Re: #CAO21-006 – 7345 SE 38th Street – Building Permit Intake

Below are our responses relating to questions that came up from our Critical Area Review 2.

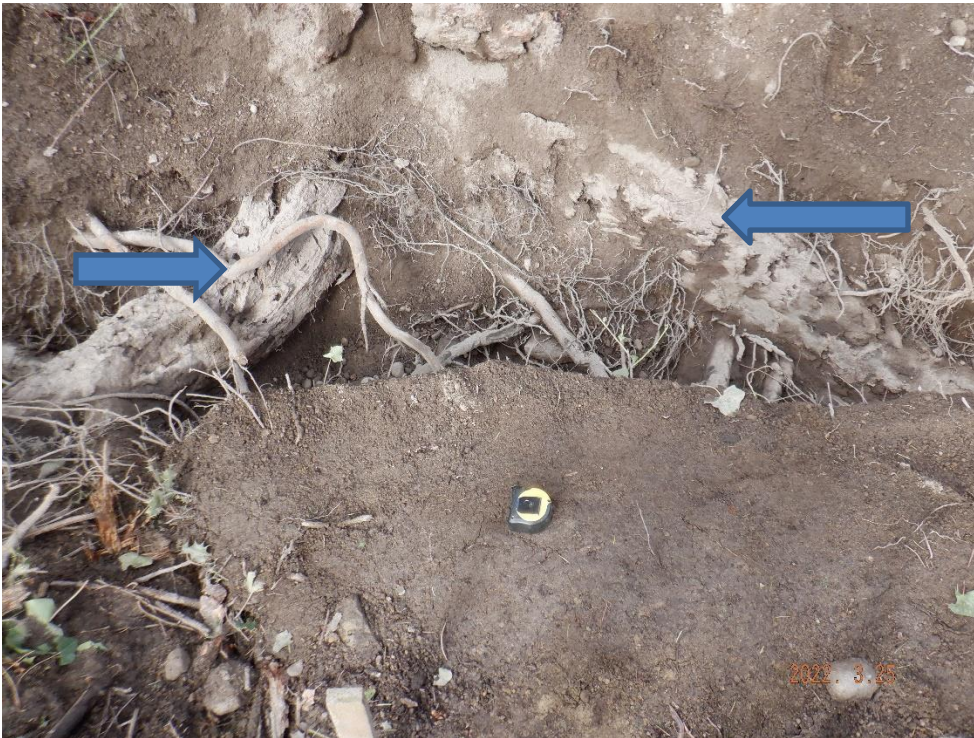
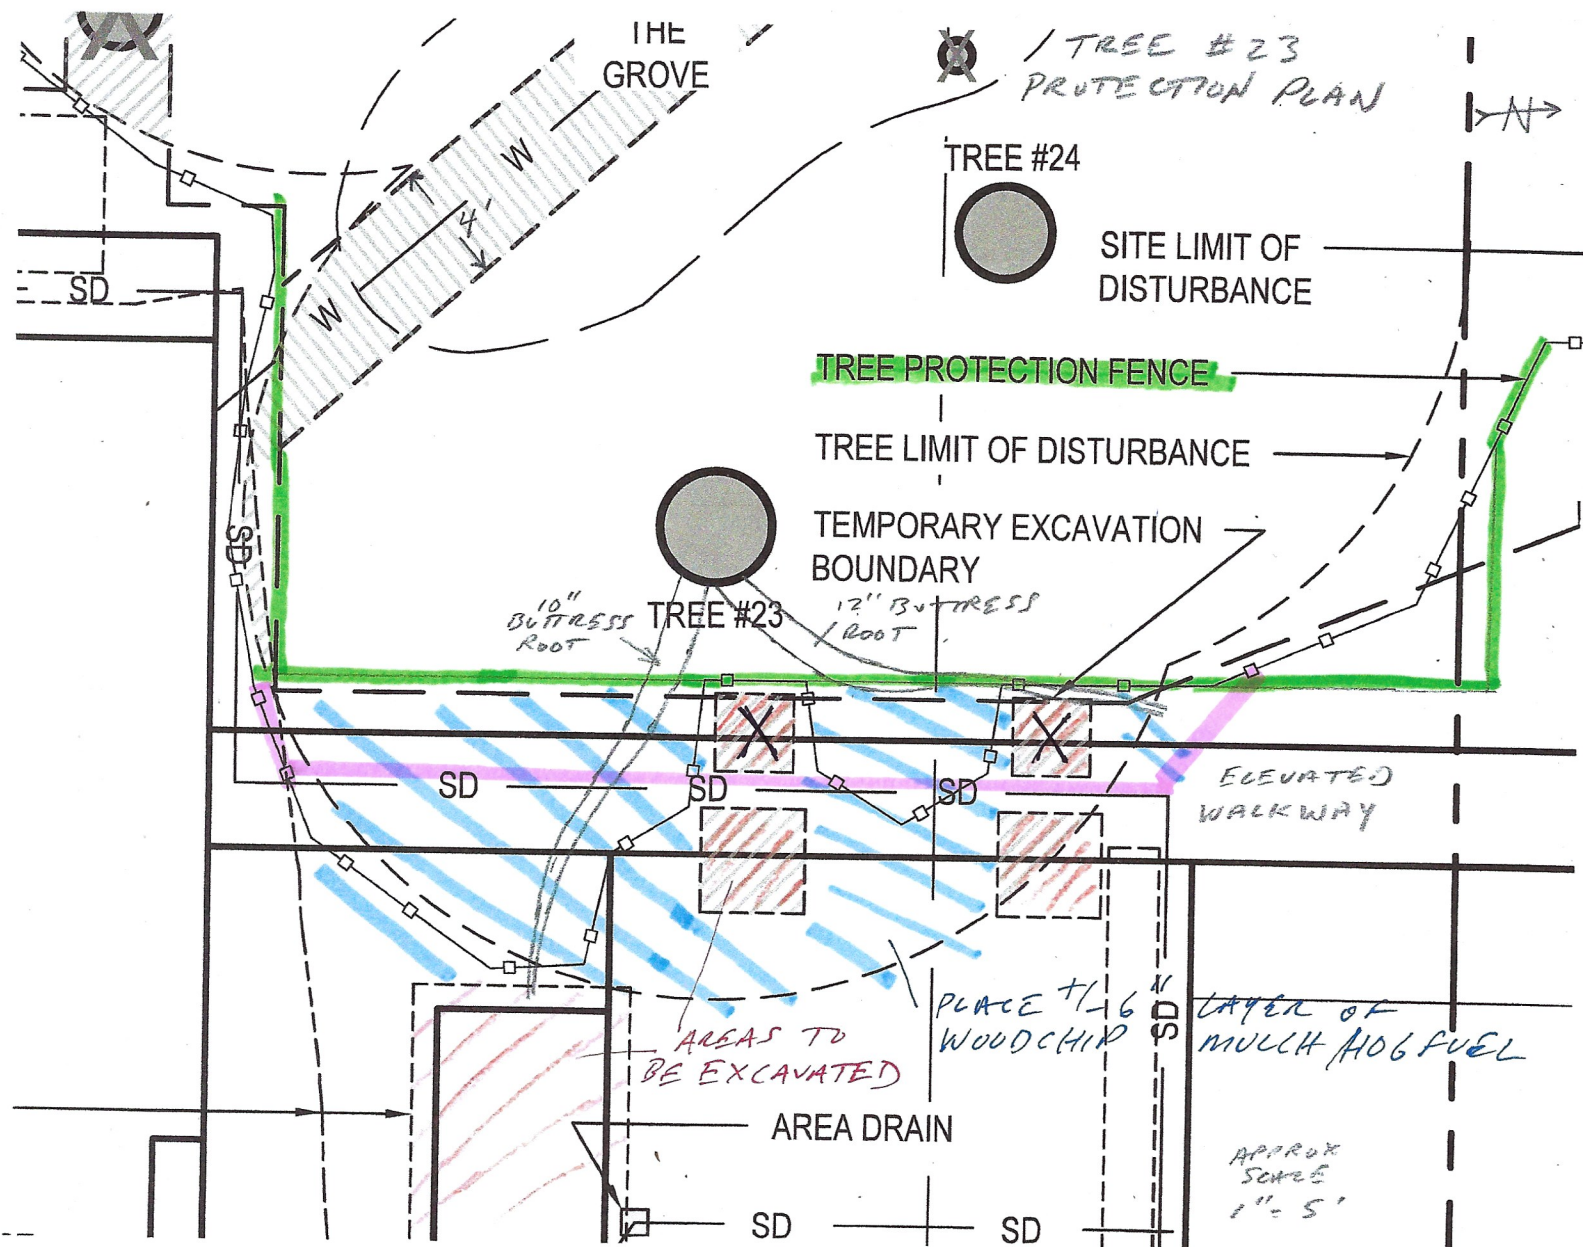
1. *Please have the arborist discuss the tree impacts of the project and describe how the code requirements of MICC 19.10.080(B)(1) and (2) are met. This process should take place for Exceptional Trees 23, B, D, and E. A full description for any encroachment into these trees' limits of allowable disturbance is required. Please be sure to provide information about how the excavation for footings will be performed and how the concrete for the site access will be poured without impacting the trees.*

- *Arborist Bob Layton addresses the tree impacts, code requirements and encroachments in his attached report.*
- **Brief Description:** Based on feedback from John Kenney and team discussions between the owner Paul Bosveld, Architect Wittman Estes, Structural Engineer Joshua Welch and Arborist Bob Layton, we decided to remove the two closest footings that had been 4 feet from the face of Tree 23. The closest footing is now 8'-6" feet from the face of the tree, and is not expected to be near roots based on air spading done in the area. The chain link tree protection fencing will now be at about 8' from the face of the tree, instead of 4'.

- We will have an Arborist on-site during excavation within the dripline
 - The two footing pads within the limit-of-disturbance boundaries will be hand-excavated only.

- For the house foundation (which lies outside the LOD of Tree 23), excavation will be done with a crawler excavator. Excavation in the area south of Tree 23 will be done towards the dripline of Tree 23. For over-excavation (~2 feet from the face of the foundation), and the slope requirement of 1V:1H above 4 feet of excavation depth, a small amount of entry in the dripline may be expected in this area. Based on an air excavation trench made at this location, only one 2" root was found which will be cut as instructed by the Arborist.

- For the utility trench, which will pass within of the LOD of Tree 23, an air spade will be used. Routing of the utilities will be adjusted to avoid or go below roots if any roots >2" in diameter are found at the depth of the utilities.

TREE RETENTION PLAN

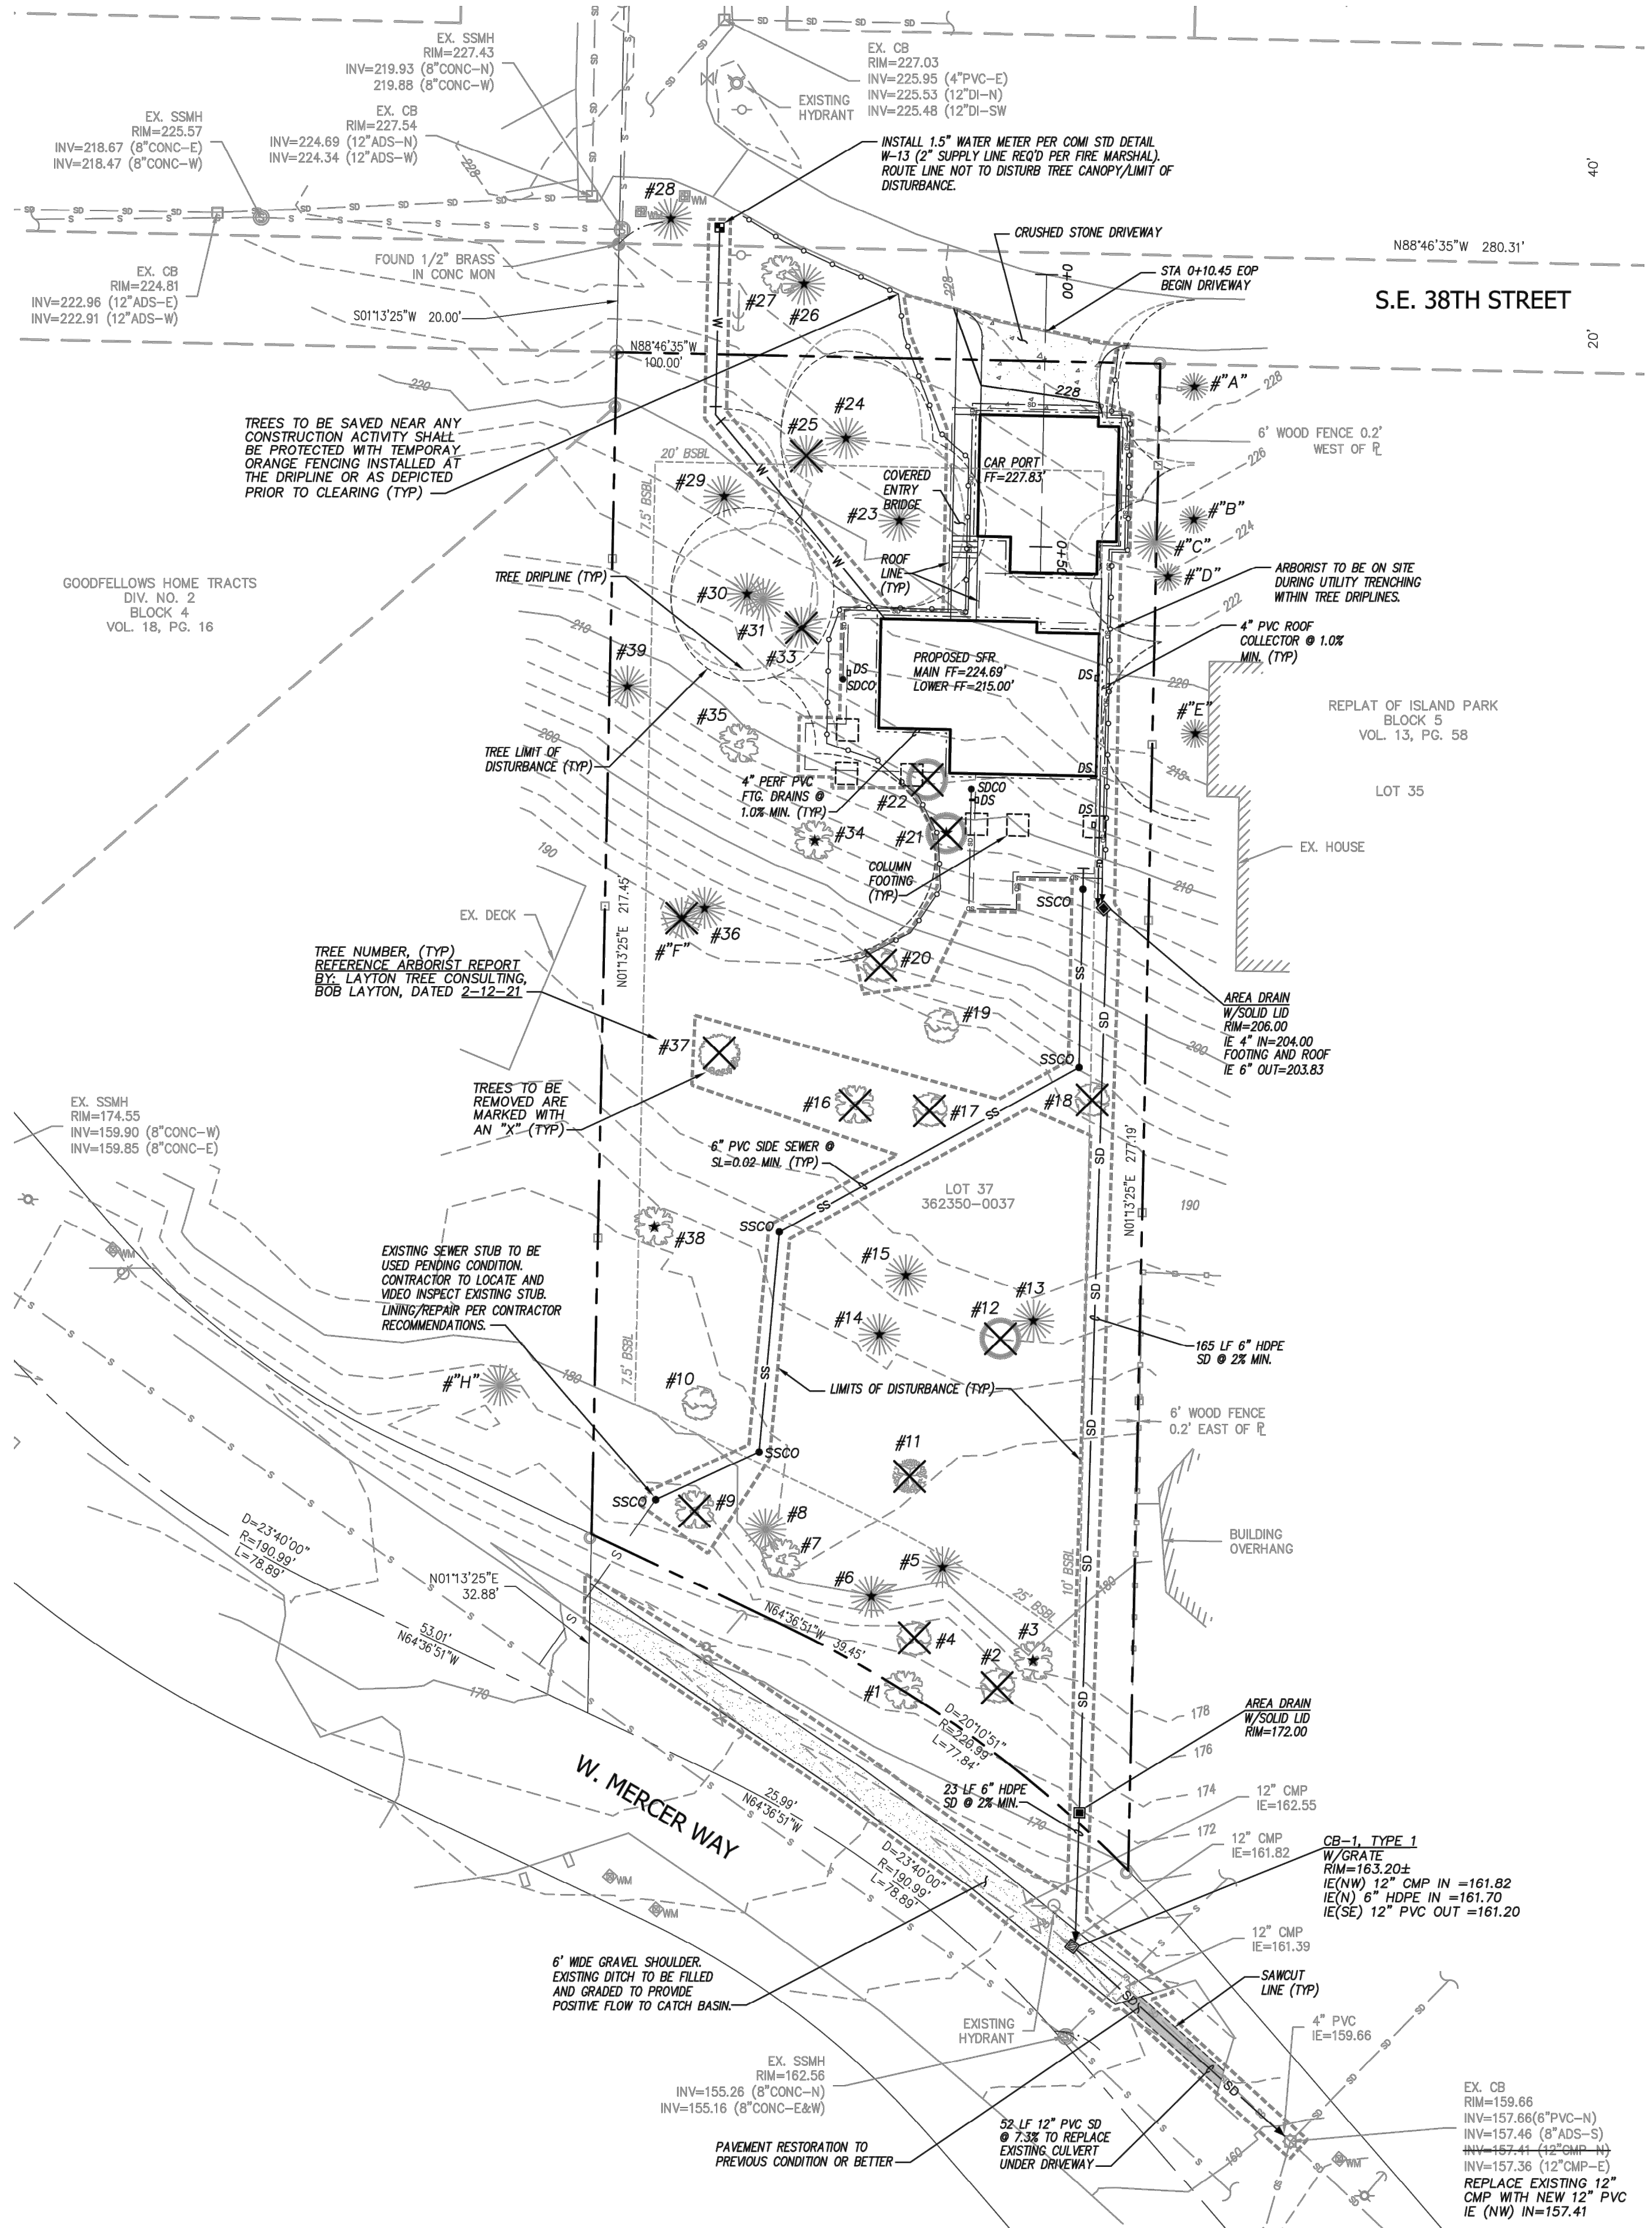
3. *Please call out the following on the tree plan:*
- a.) The distance from the face of the trees to the tree protection*
 - b.) The chain link fence for all saved trees*

Fencing shown on the attached Tree Retention & TESC Plan on Sheet C2.0 has been revised to call out chain link fencing and now includes the distances from the fencing to the face of the trees.
